CITY OF ALBUQUERQUE

July 9, 2012

RE: **Casitas de Colores – Conceptual** Grading & Drainage Plan for Site Development
215 Lead Ave. S.W. P.E. Stamp: N/A (**K14-D087A**)

SHEET NO. **CG-101**
OF

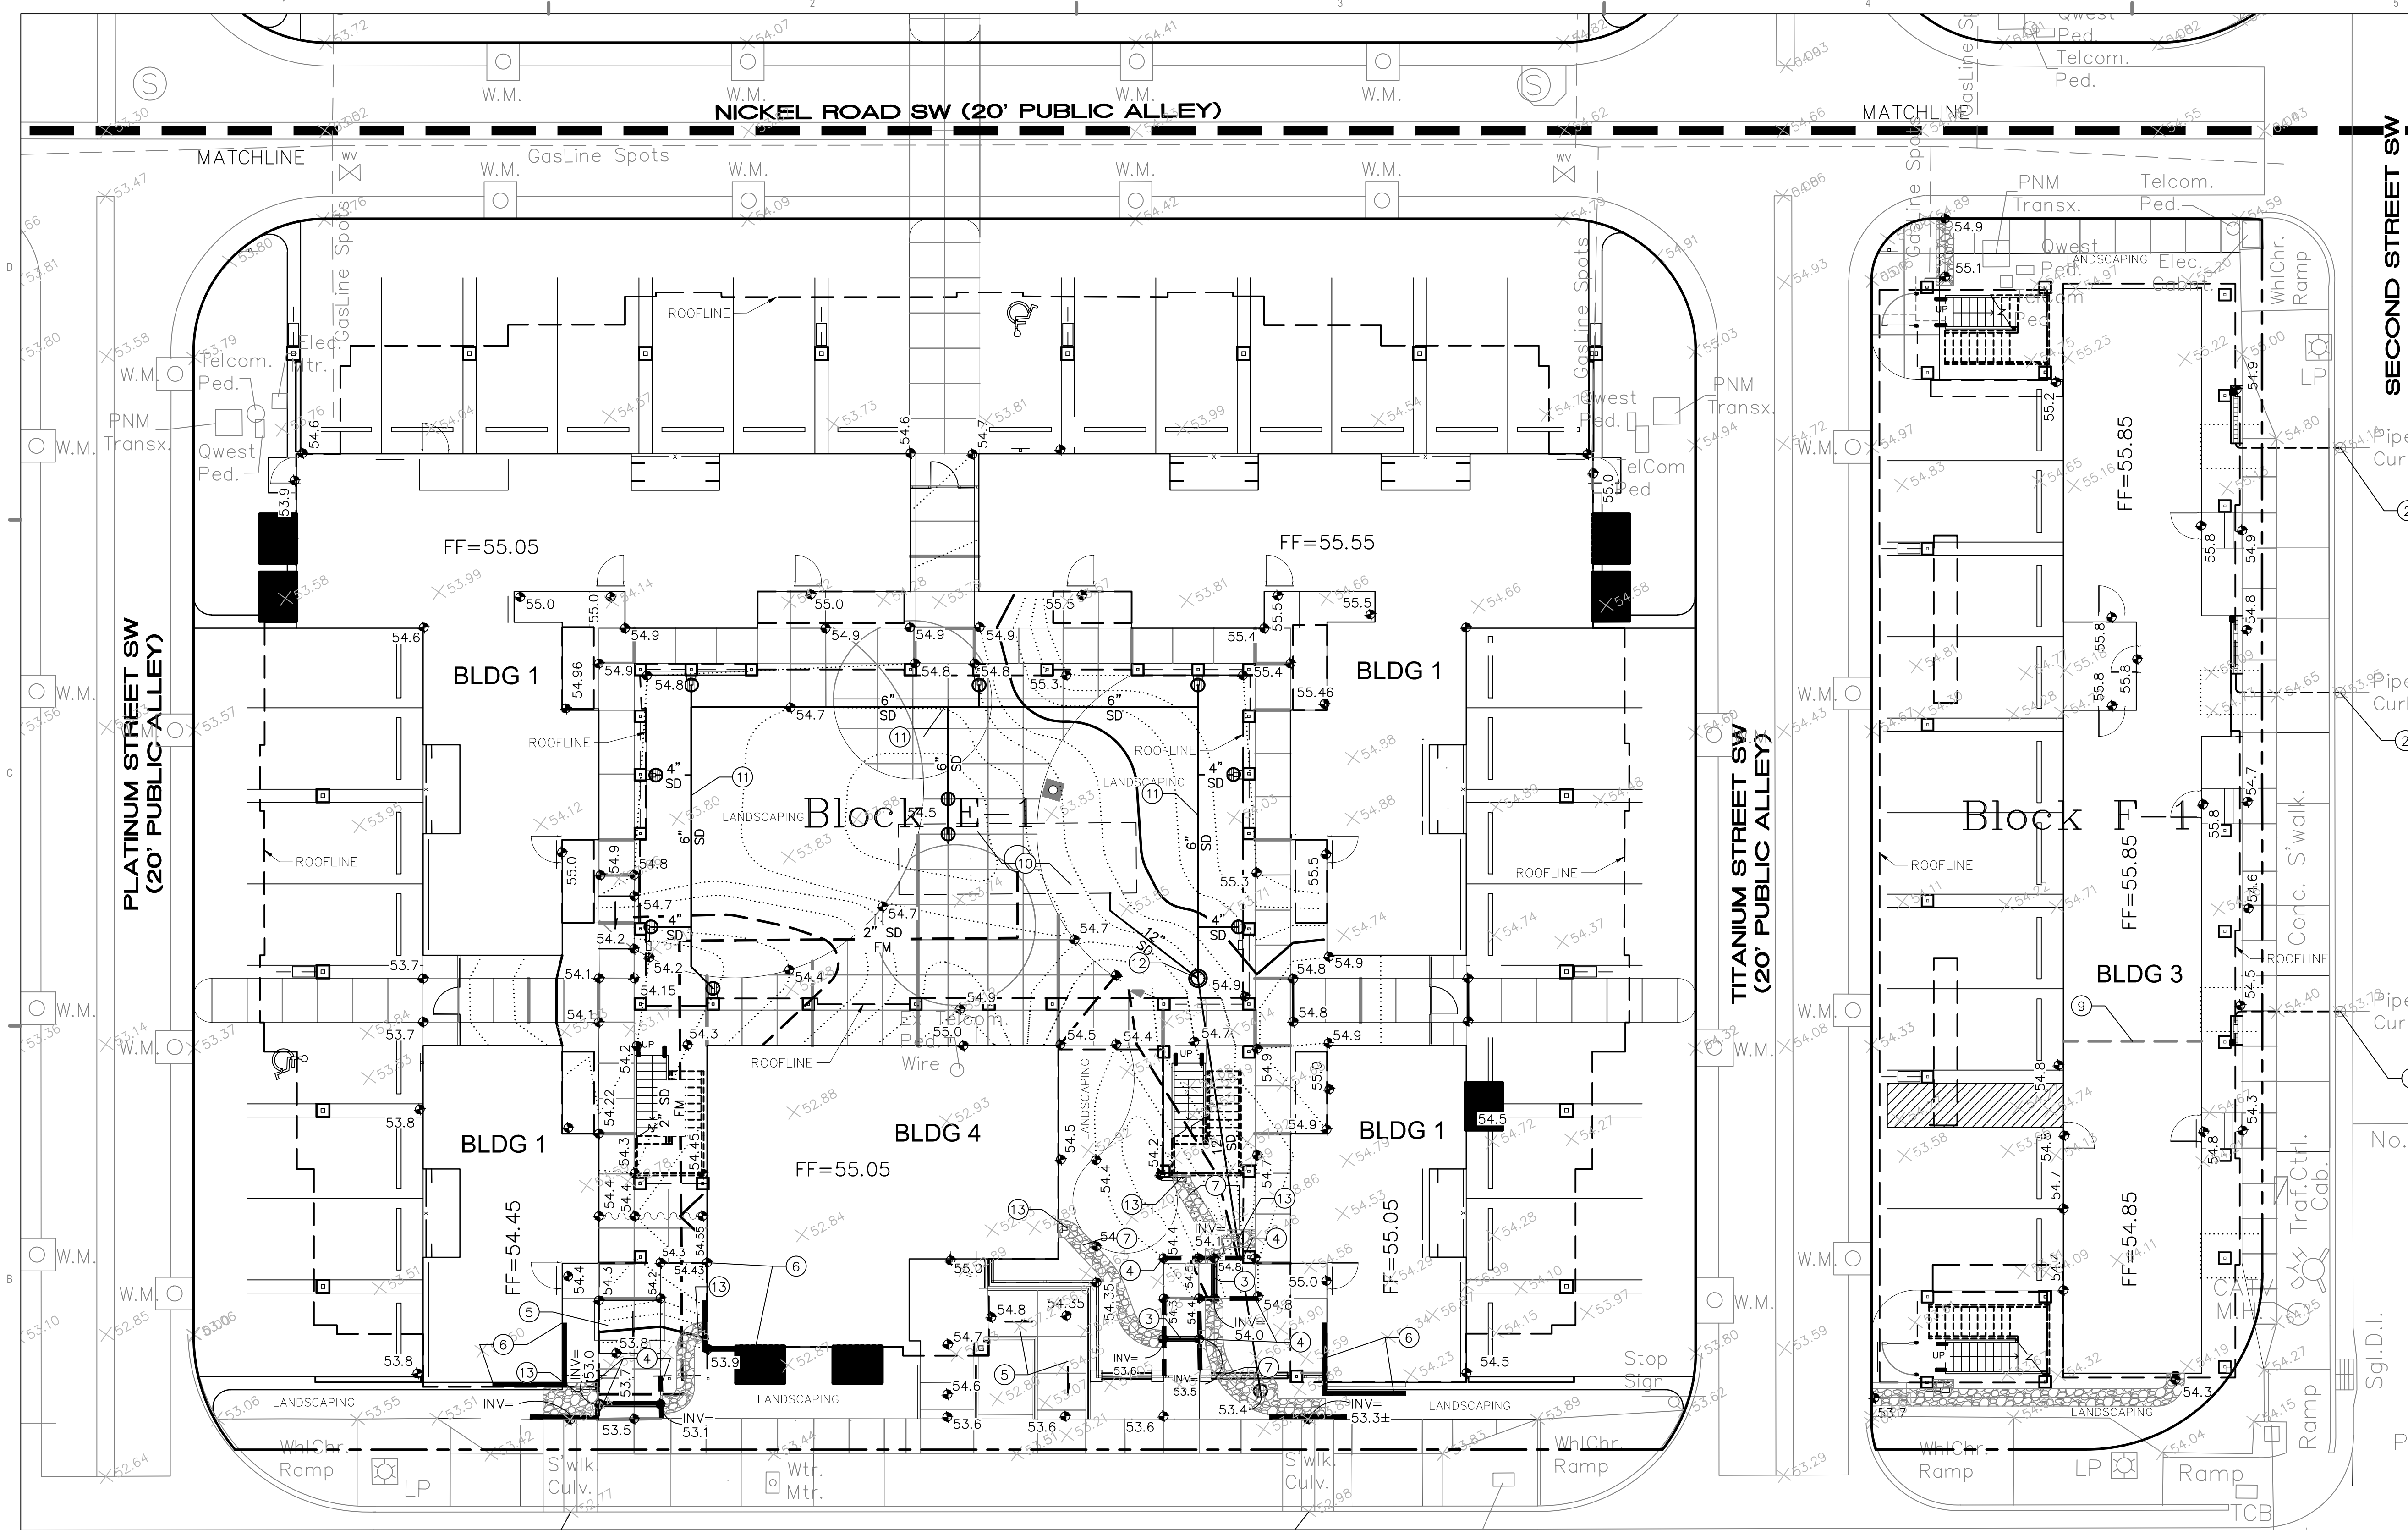
1. To ensure capacity in the valley drainage system, Department policy requires the site discharge rate from valley developments to be limited to 2.75 cfs/ac, unless greater capacity to the river can be demonstrated.
2. Provide calculations to demonstrate compliance, and details of onsite detention facilities to meet the required discharge rate.
3. Provide labeling of roof lines and other impervious improvements, along with proposed permeable areas and conveyances.
